**Consultation Response from KC,
Highways Development Management**

2023/92966 Land to the rear of, 271, Cliffe Lane, Gomersal, Cleckheaton, BD19 4SB

Demolition of existing dwelling and erection of 87 dwellings including formation of a new access from Cliffe Lane, landscaping, public open space and all associated infrastructure and engineering works

Date Responded: 25-1-2024.

Drawing Number	152130-001	Rev	A
----------------	------------	-----	---

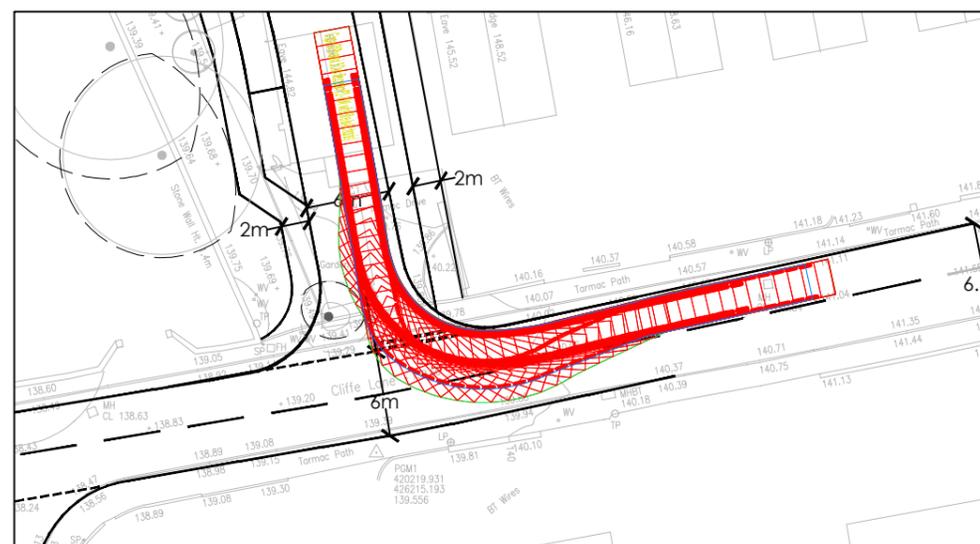
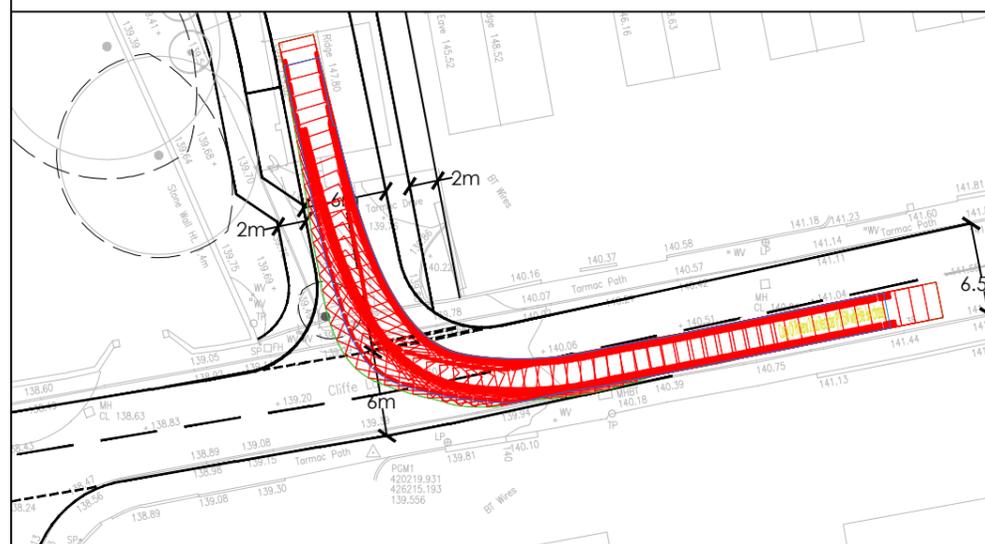
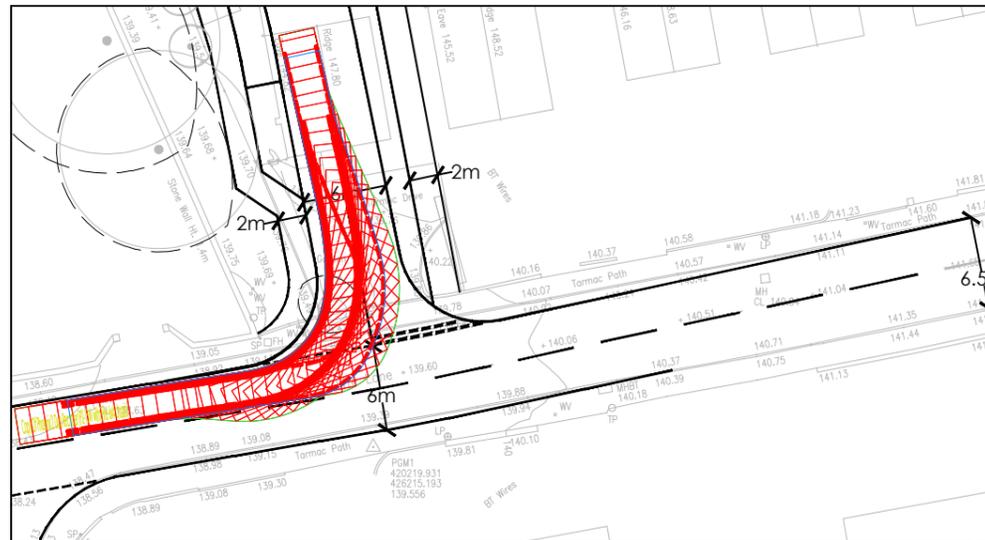
7. A plan showing swept paths and visibility needs to be provided for our review. This plan must also be annotated with dimensions of the proposed road widths.

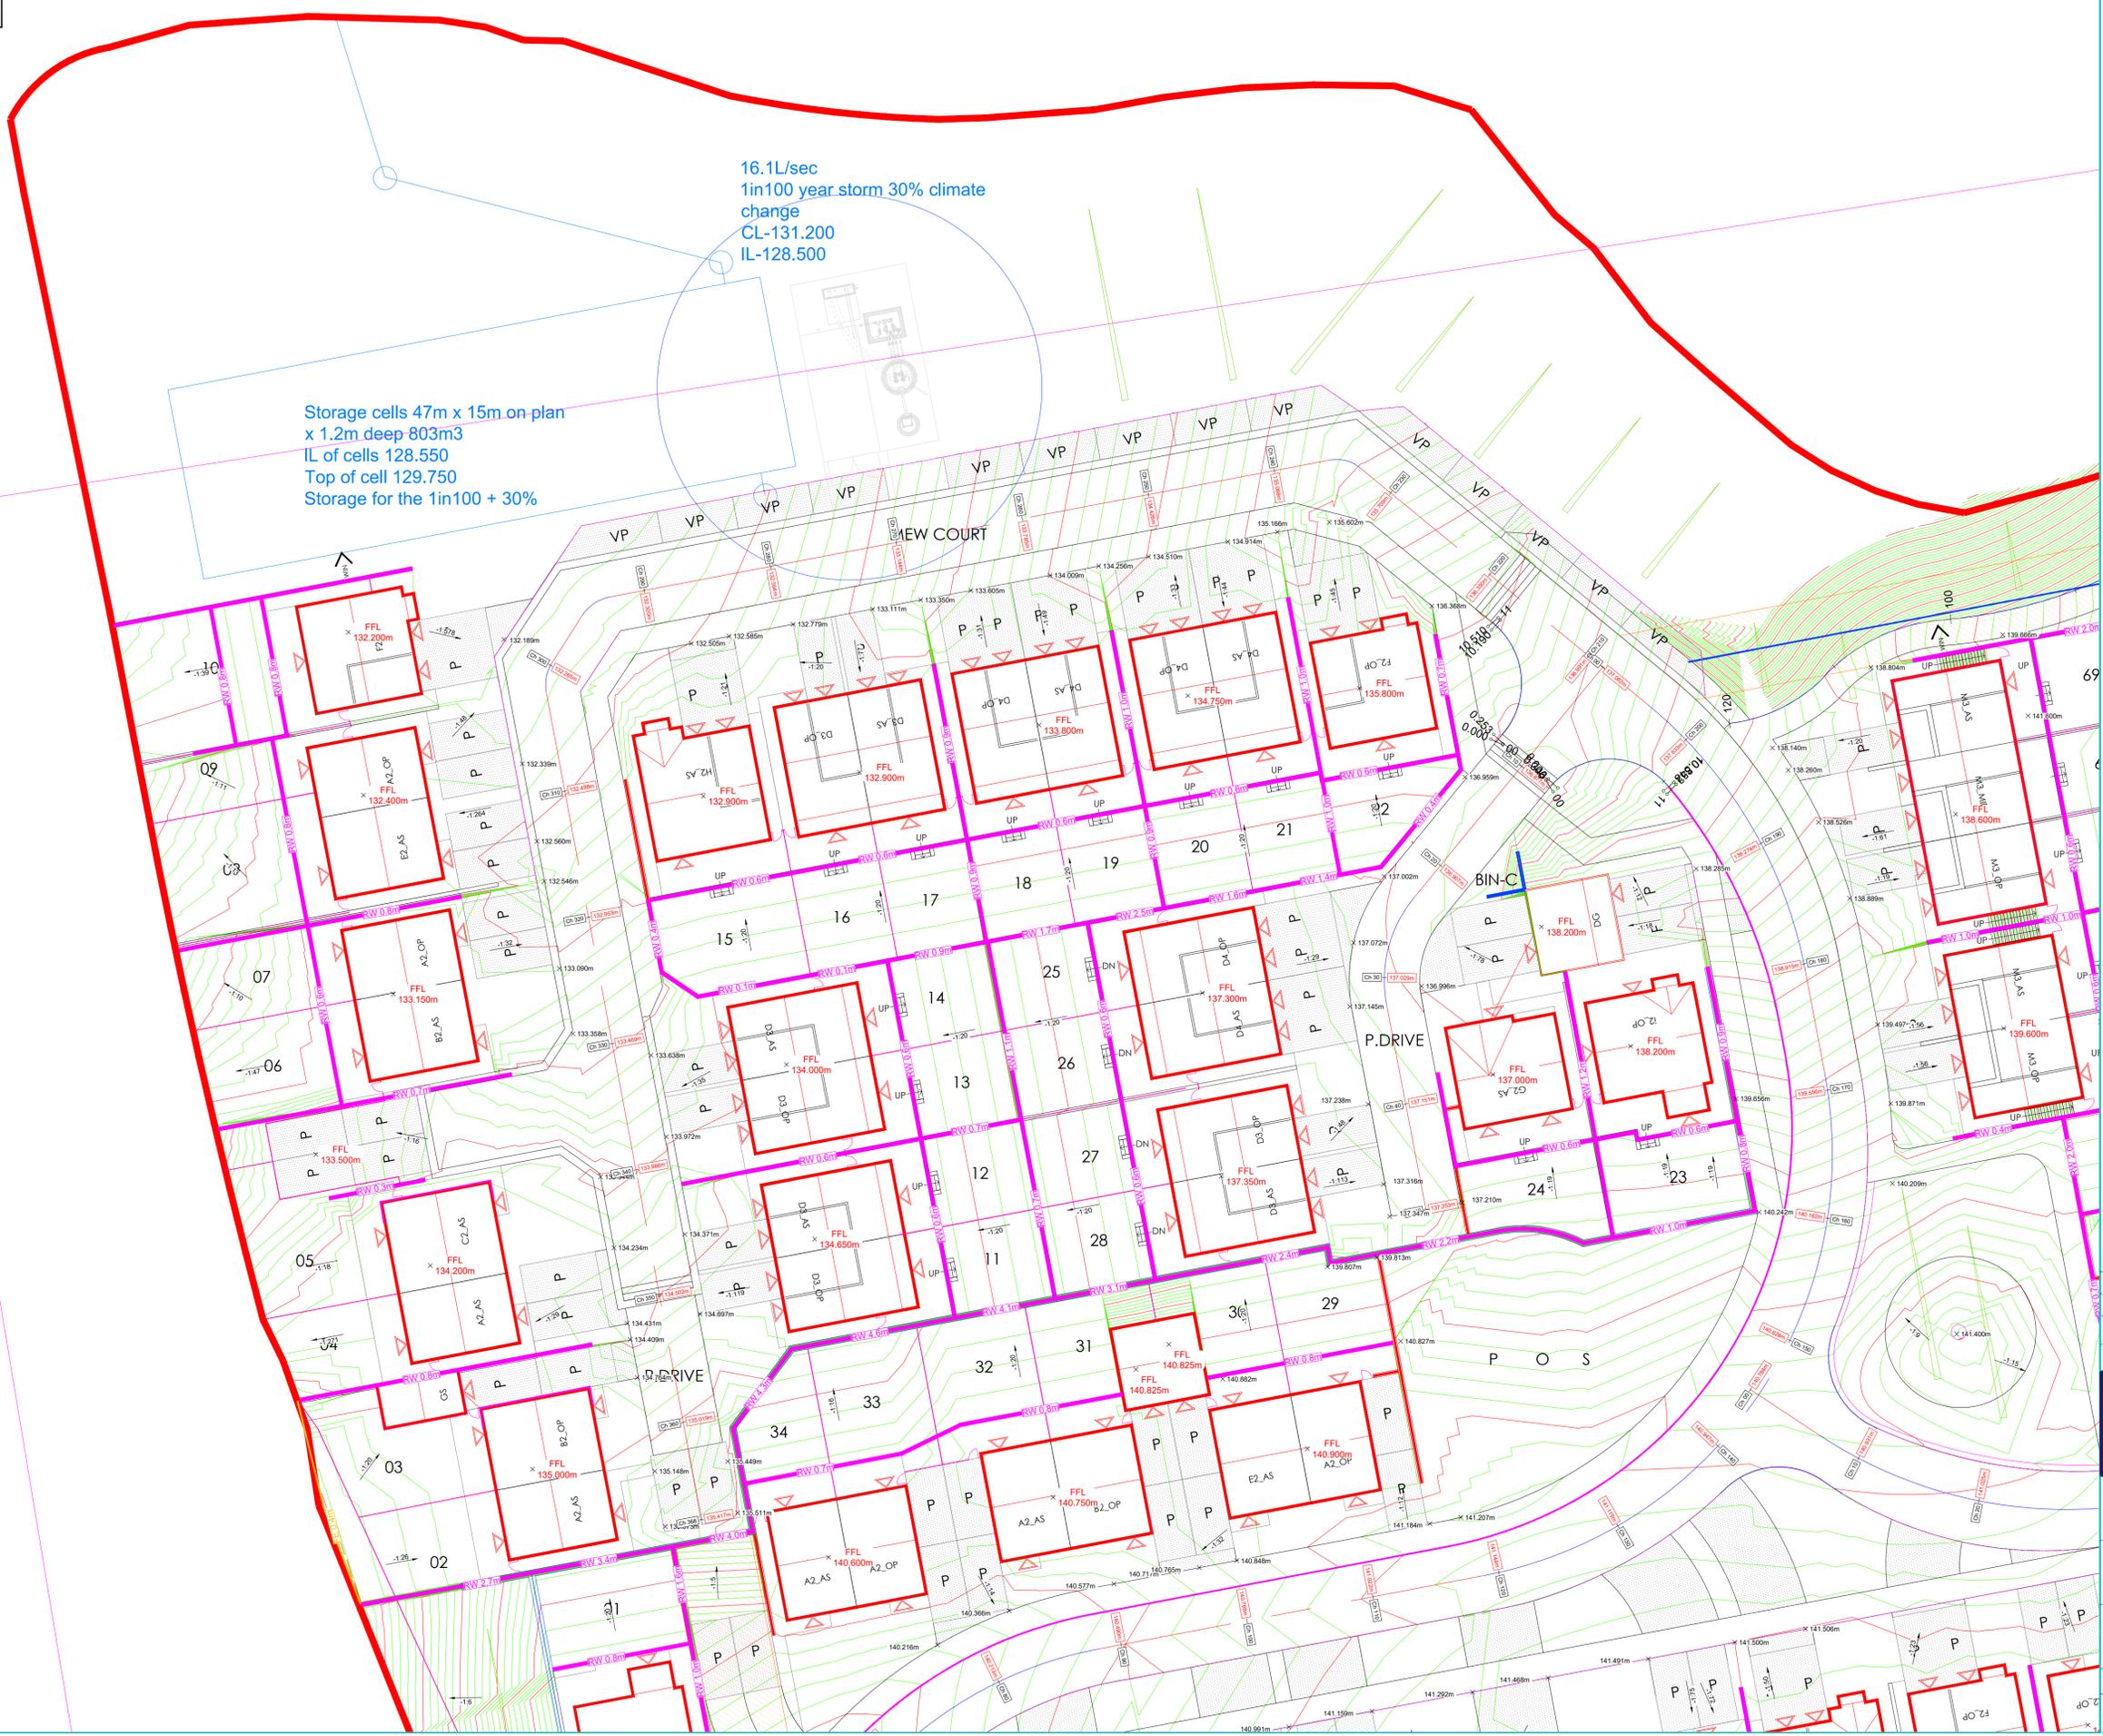
5, Details of proposed road gradients should be provided.

8. I am unable to comment on longitudinal levels on this occasion as that information is not available, but all share spaces should not be steeper than 1:20 as per my previous comments.
